**CITY OF ALBUQUERQUE
PLANNING DEPARTMENT
June 17, 2015
DRB Comments**

PROJECT # 1007715

APPLICATION # 15-70225

RE: Lots 1-3, Lands of Bryant & Whitaker

EXISTING CONDITIONS

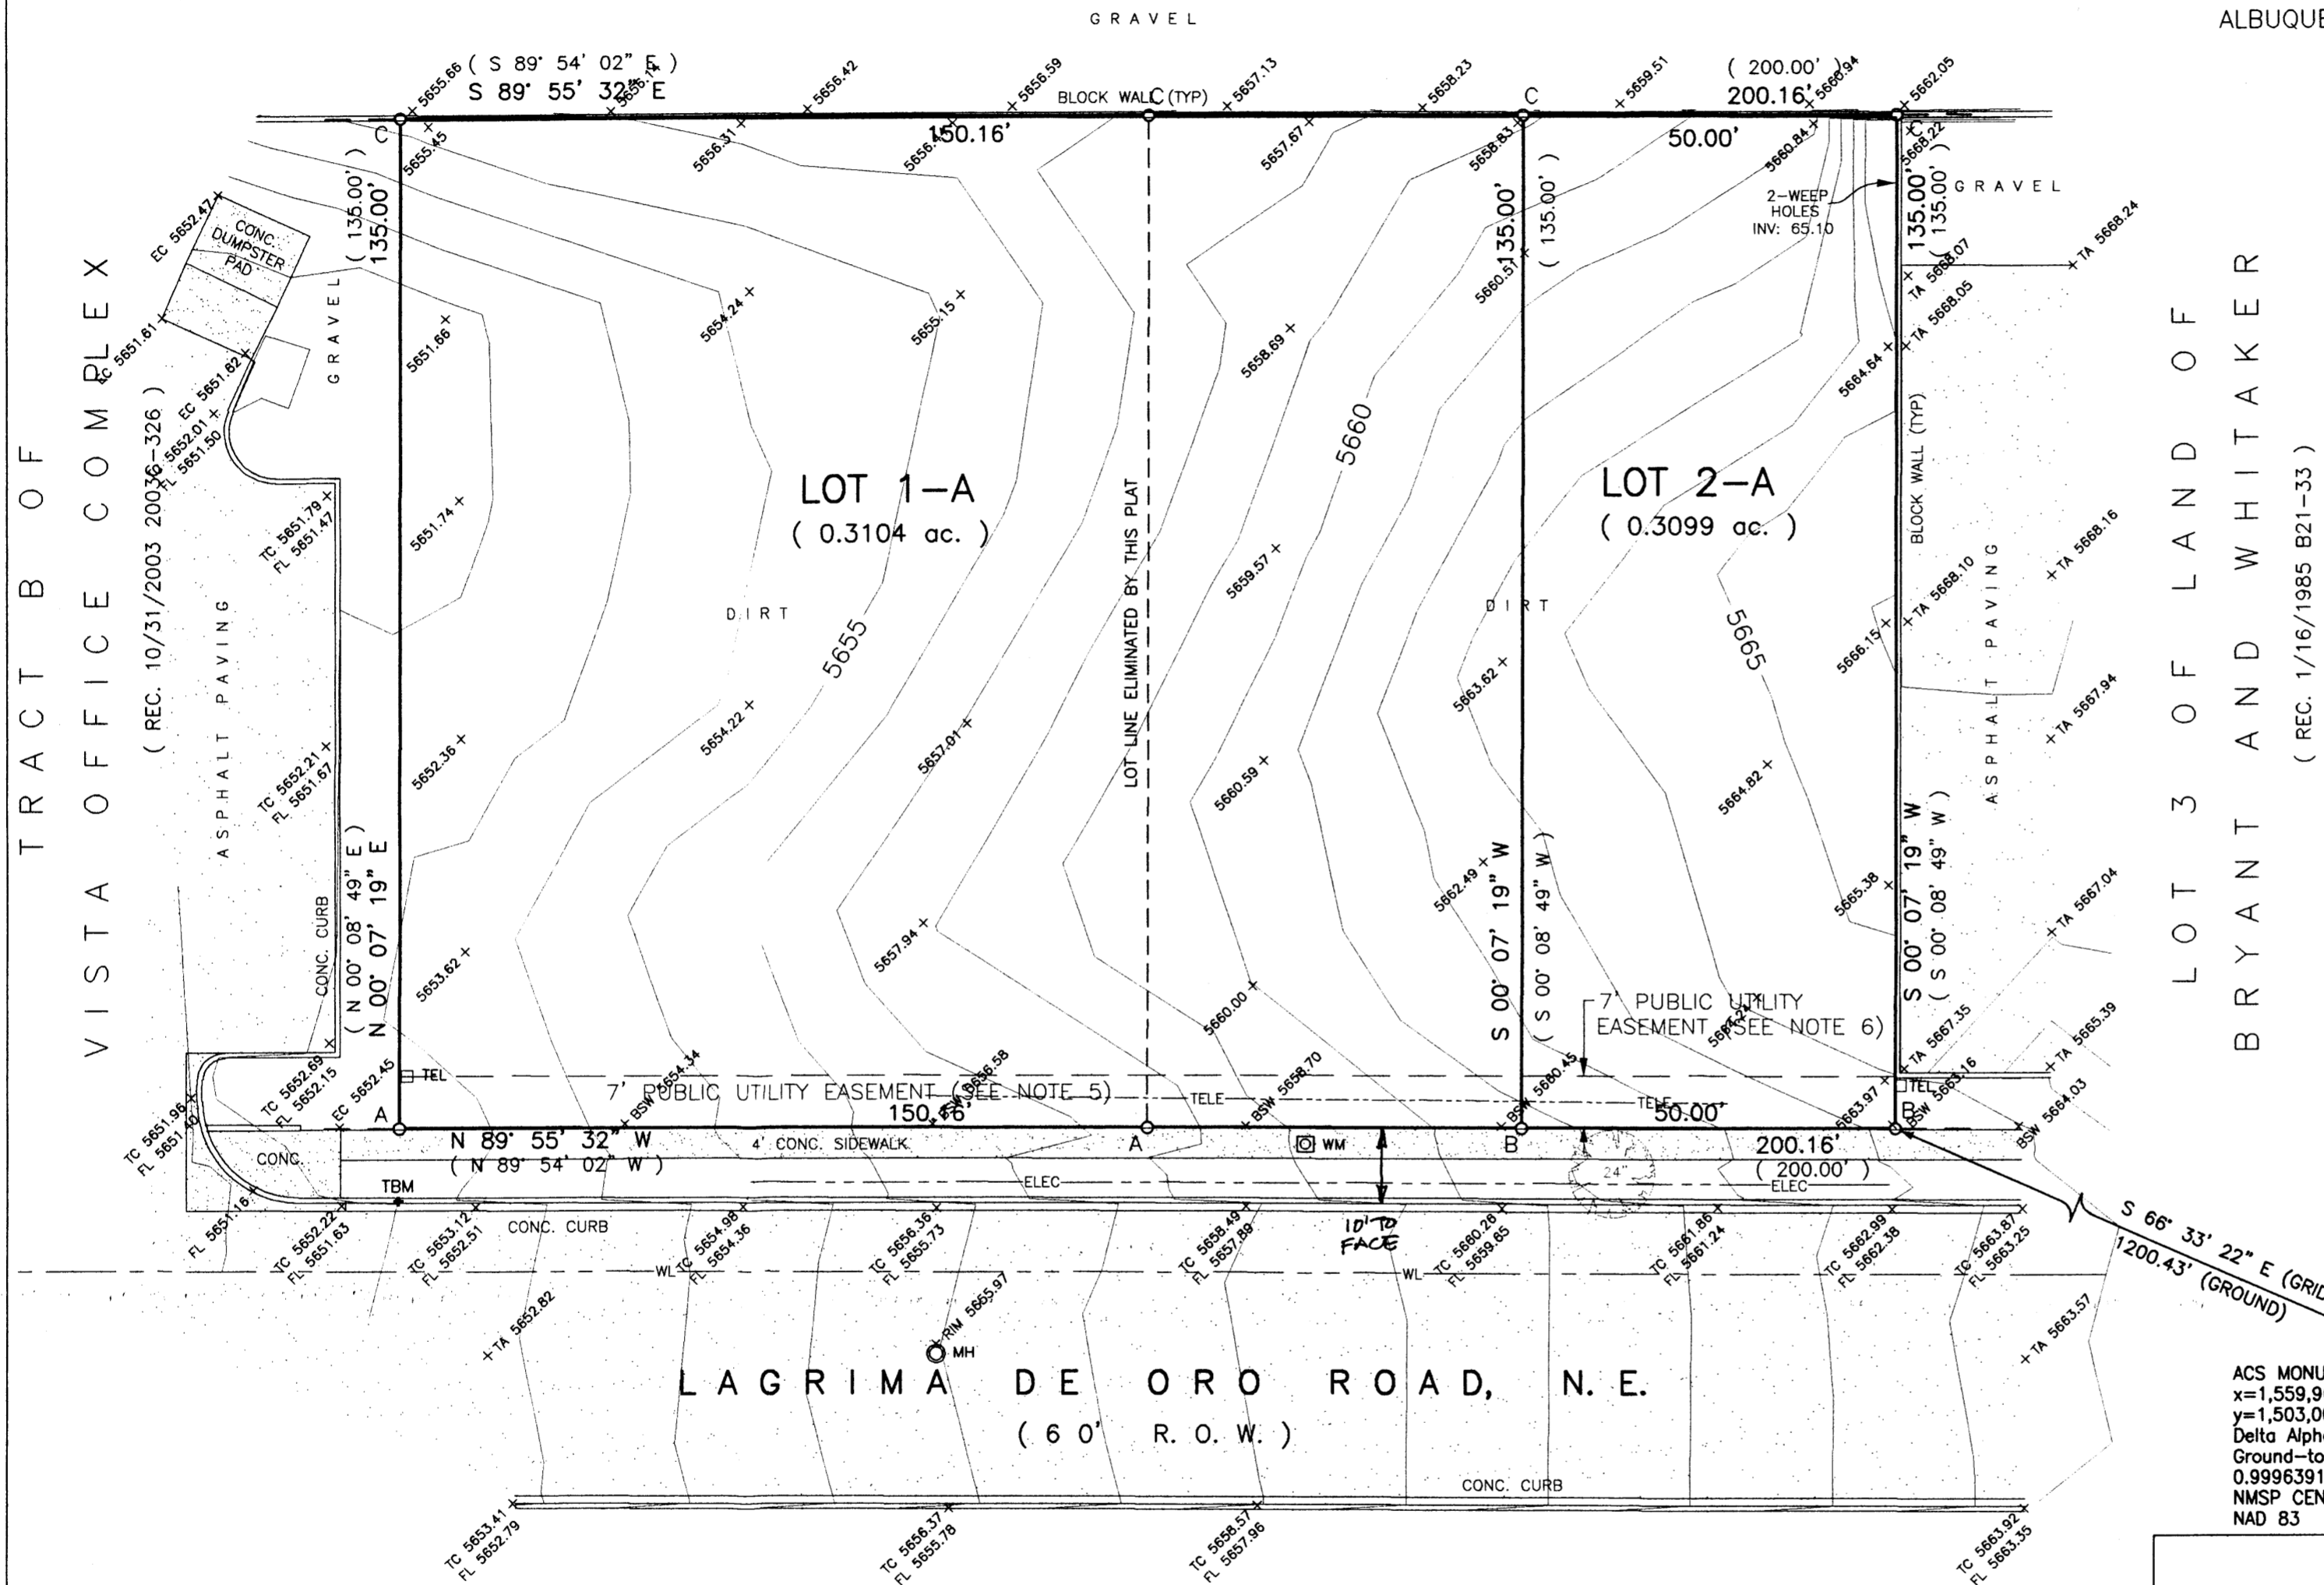
While there is no minimum lot size in the O-1 zoning district, the proposed 50 lot width will severely restrict development options on proposed Lot 2-A. It is advised that a draft site plan be developed to demonstrate potential development and compliance with zoning regulations (e.g. setbacks, parking, landscaping, etc.).

Reducing the size of Lot 2-A may make it difficult to develop Lot 2-A (zoned O-1).

Planning concurred
